# CUMNOR PARISH COUNCIL

## **BOTLEY WEST SOLAR FARM (BWSF) REF: EN010147**

### **Cumnor Parish Council's Comments on Submissions received at D3 - Consultation on proposed changes**

### **Cumnor Parish Council's response to the applicant's consultation (23<sup>rd</sup> July 2025-22<sup>nd</sup> August 2025) on proposed changes**

**Operational Development Plan
Southern Site Area**

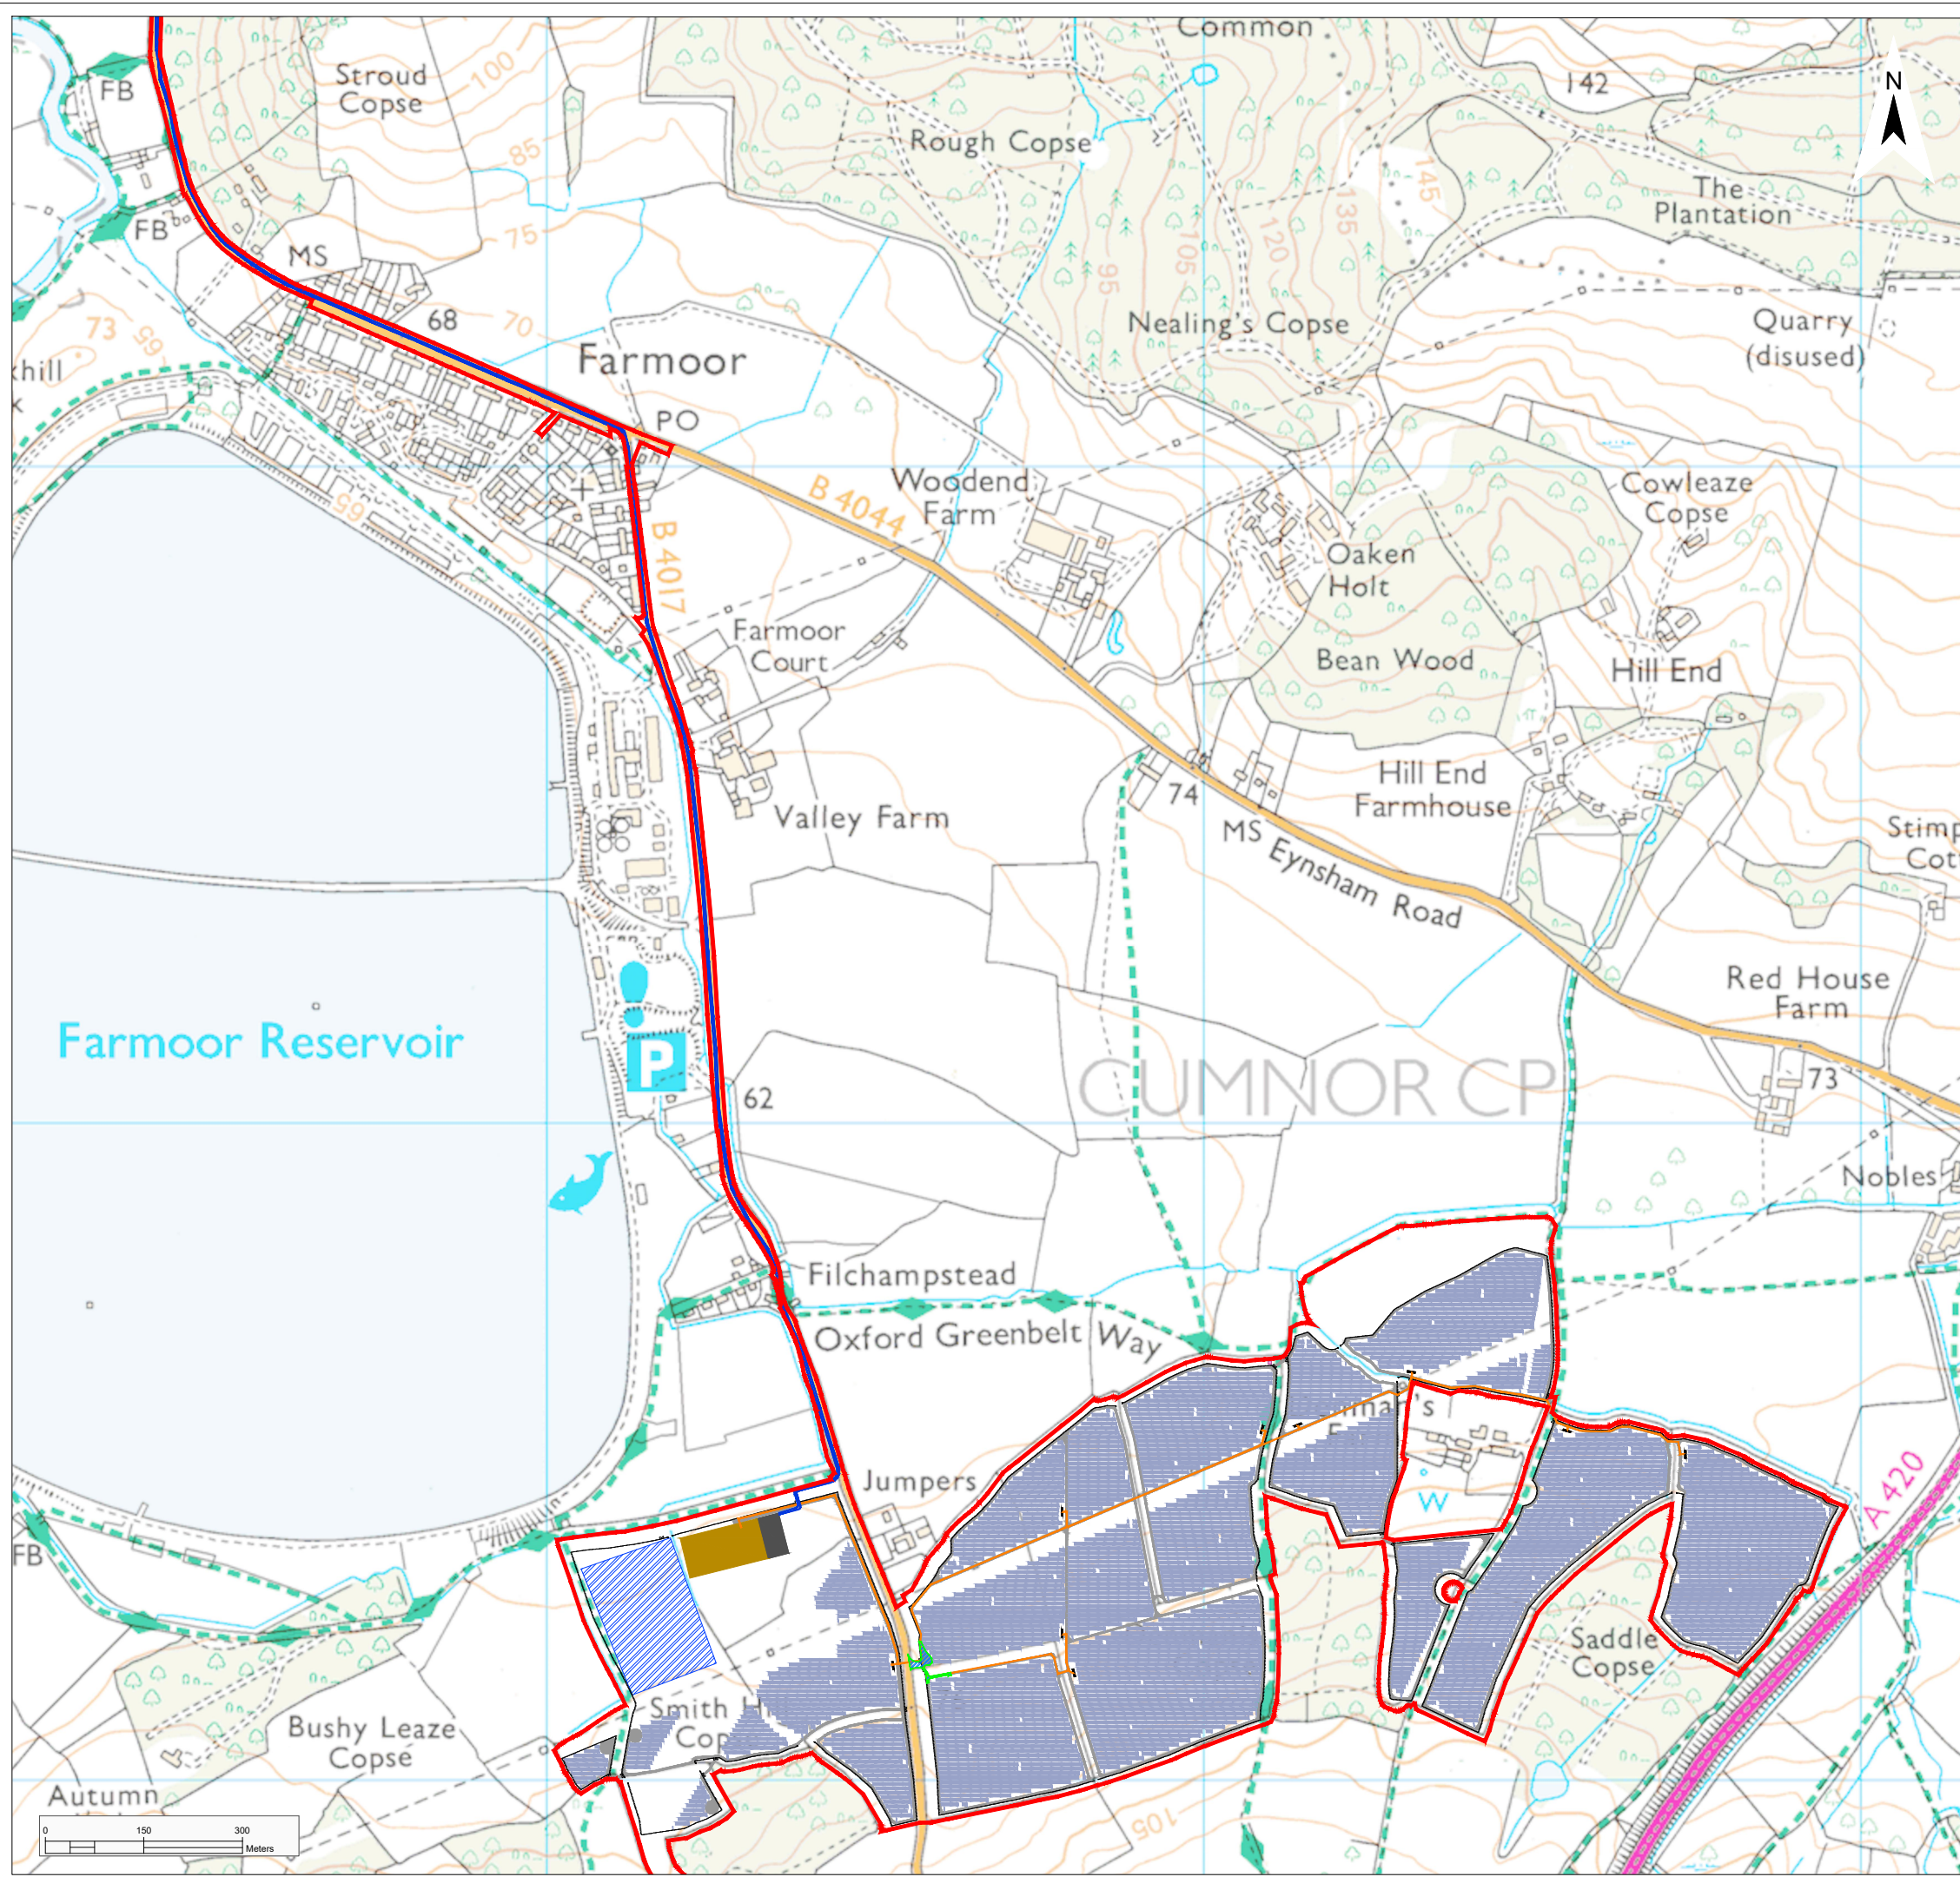
9. The proposed position of the main Project substation places it immediately adjacent to PRoW 184/30/40 and 184/29/10 and within a few metres of 184/30/20 (the Oxford Greenbelt Way).

As such, and given its permanent, not 'temporary', nature it will irretrievably change the kinetic experience of walking those PRoW; the setting of Upper Whitley Farm (Grade II) (see also para 9 - **ExA q1.6.29** - in **EN010147-001336-Cumnor Parish Council - Comments on responses to the Examining Authority's First Written Questions (ExQ1)**); will be visible to recreational users of Farmoor Reservoir, and will be completely visible, with no possibility of mitigation given elevation changes, from Cumnor Neighbourhood Plan (CNP) Important Views 3, 7 and 31.

10. The applicant's proposed change of an additional 2.41ha of panels would place the panel arrays immediately adjacent to PRoW 184/22/20 to its south and west.

The proposed immediately adjacent Red House Farm solar power station plans to install panels, fencing, CCTV etc. to the north and east of the same PRoW (see for example para

The cumulative impact, which the applicant has repeatedly failed to address (see for example para 2.2 of **EN010147-001136-Cumnor Parish Council - Responses to Examining Authority's First Written Questions (ExQ1)** and para 10 of **EN010147-000887-Cumnor Parish Council Written Representation Ref EN010147 30th May 2025**), would be to create a canyon for the PRow surrounded by industrial scale equipment, fencing and CCTV, in what is currently open Green Belt farmland.

11. The applicant's July 2025 Explanatory Note for the Change Request<sup>1</sup> lists on page 12 the following *'approximate design parameters'* *'On an indicative basis only at this stage'* for the proposed NGET substation:

- *Up to 3.8ha site area*
- *93.020m x 16.725m footprint of main GIS building*
- *14.495m height of main GIS building*
- *Gas Insulated substation*
- *95 dB(A) sound power level*
- *105.020m x 10m footprint of adjoining building*
- *4.8m height of adjoining building*

Thus, the main building has grown from 76m x 31m by 14m high (**REP1-014**) to 93.020m x 16.725m by 14.495m high.

In the UK, 95dbA, according to HMG<sup>2</sup>, is considered *'above the permitted exposure level and requires hearing protection. Exposure to 95 dB(A) for 50 minutes is the equivalent of the maximum daily noise dose for unprotected ears'*

This would clearly transform the site, immediately adjacent to the Oxford Green Belt Way and other PRow, into both a visual and noise site typical of a major industrial enterprise, with consequential impacts on humans and wildlife.

**CPC does not believe this statement to be true, and in light of the above requests that the relevant – and now outdated – LVIA be repeated, and that a noise envelope assessment also be undertaken, the results being overlaid with bat roosts and flightpaths to allow their disruption to be assessed.**
